Mountain View Electric Association, Inc. (MVEA) has these comments about following:

Project Name: Academy Village, Filing #3 Landscaping

SHEET TITLE
 PLANTING PLAN,
 DETAILS
 AND NOTES

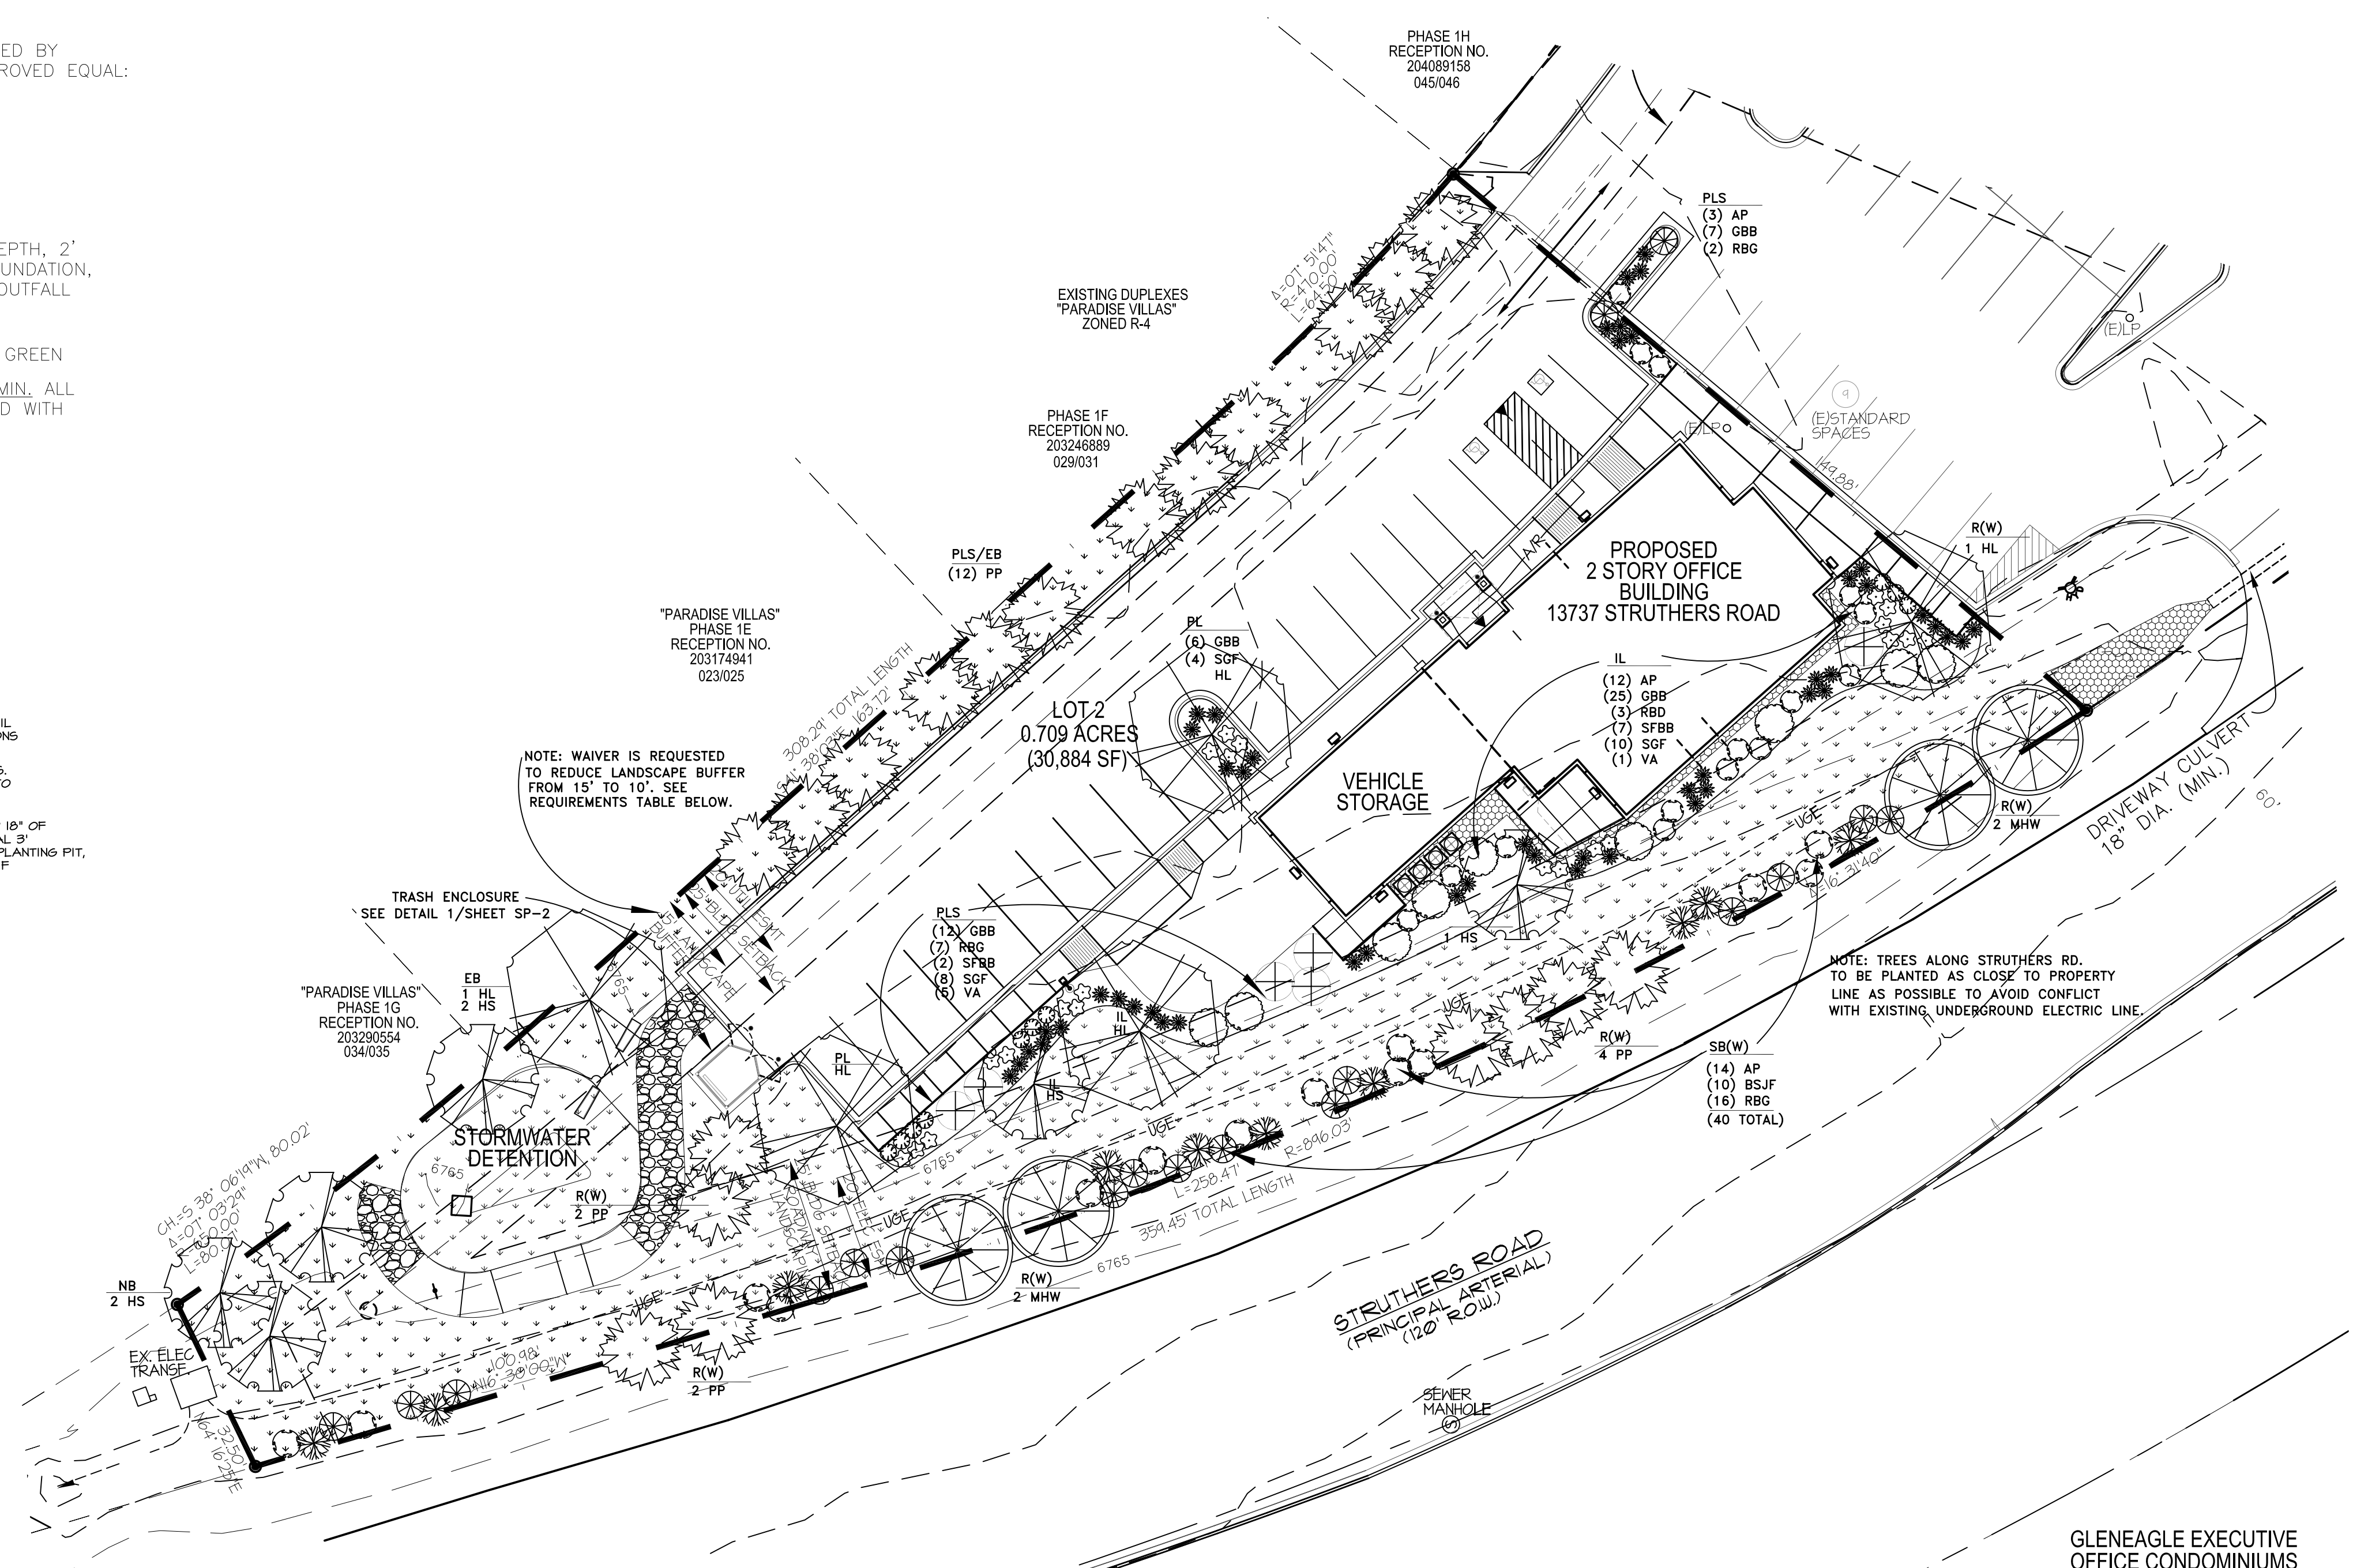
MVEA has no objection to this lot specific landscaping plan as presented by Ms. Anderson with the understanding that MVEA has existing facilities within this parcel of land and request that deep root plants be placed no closer than 5 feet from any electric line and 10 feet from any above ground electric facility.
